WEST SUSSEX COUNTY COUNCIL CONSULTATION

TO:	Arun District Council FAO: Simon Davis
FROM:	WSSC – Highways Authority
DATE:	21 October 2025
LOCATION:	Land West of Pagham Road Pagham PO21 3PY
SUBJECT:	P/135/25/DOC Approval of details reserved by condition imposed under P/178/21/OUT (APP/C3810/W/22/3302023) relating to conditions 9-recommendations of supporting survey reports, 10-resurvey for water voles or badgers and 16-Construction and Environmental Management Plan (CEMP).
DATE OF SITE VISIT:	n/a
RECOMMENDATION:	Advice

Comments are made against condition 16 (Construction Traffic and Environmental Management Plan) only.

7. Off site traffic Management

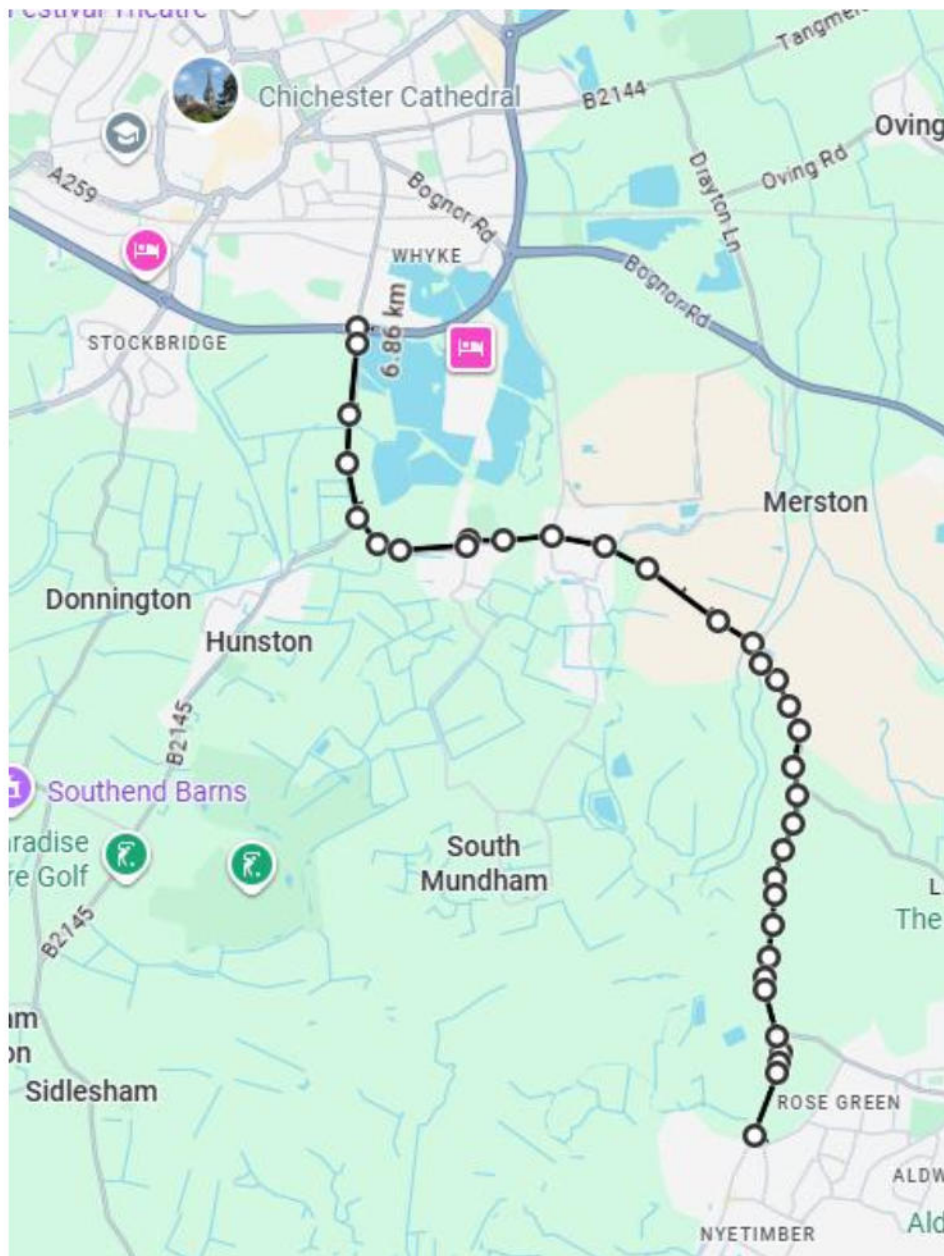
Part 7 deals with traffic routing. The assumption is that all deliveries would arrive and depart to the north via the B2166 towards Chichester. It's not unreasonable to expect that some movements may arrive/depart to and from the east. In these respects, the CTMP should identify a potential route.
